Our Ref: LU/77/18/HH
Your Ref:

Town & Country Planning Act 1990 (as amended)
Town & country Planning (Development Management Procedure) (England) Order 2015
Application for Planning Permission for Works or Extension to a Dwelling

Development Single storey side & rear extensions (resubmission following LU/355/17/HH).
Location 16 Madehurst Way Littlehampton

DRAWING BLOCK PLAN DATE: OCTOBER 2017 DRAWN: T. Murray	SCALE 1/500
DRAWING: 17/46/3A	REVISION:

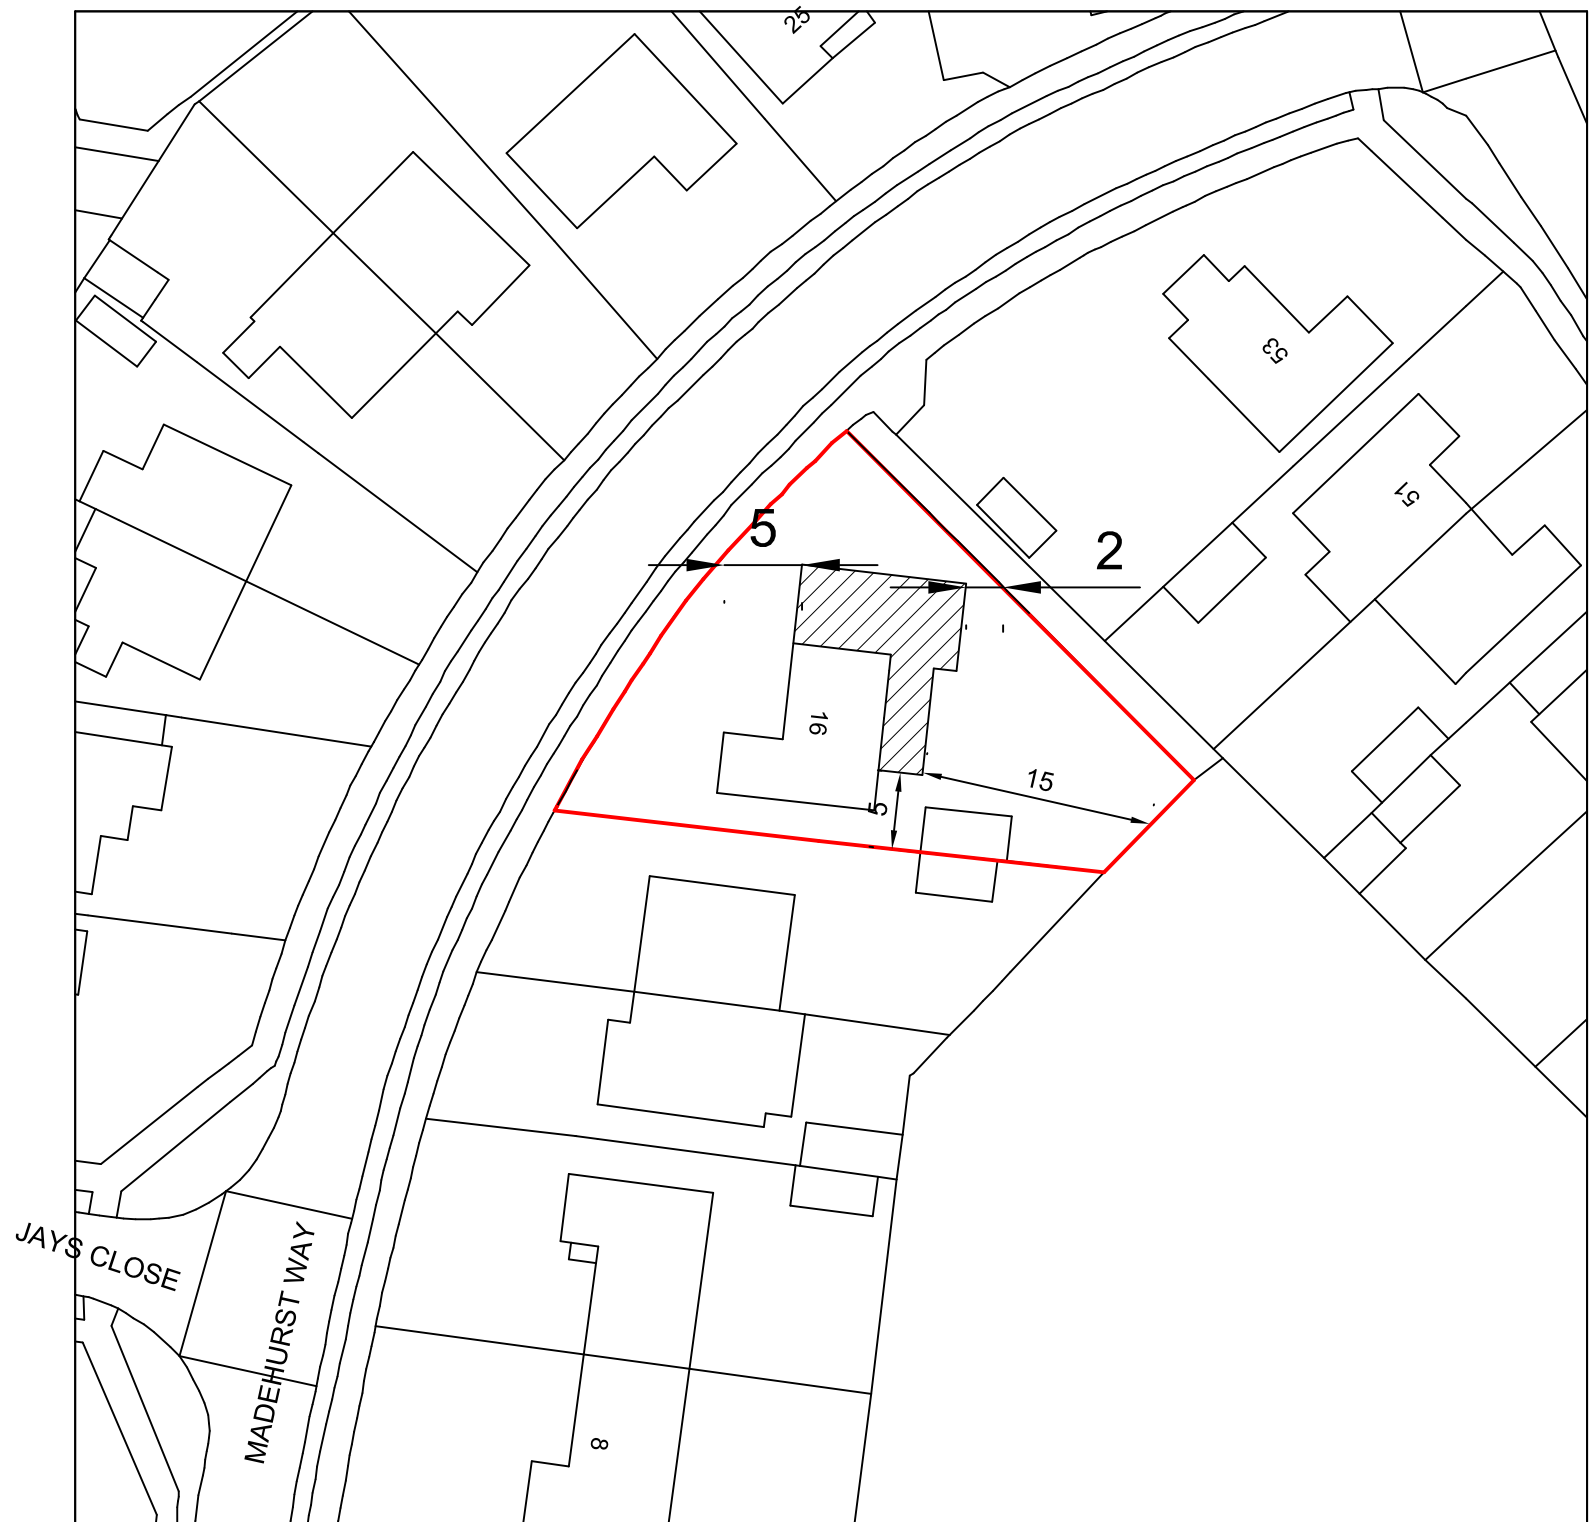
Block Plan Amend

Please submit 1 electronic or 3 paper copies of a block/site plan at a scale of 1:500 or 1:200. Further details of what must be included on the plan can be found in the National Validation Requirements. Please highlight all proposals and provide measurements from the proposals to the site boundaries.
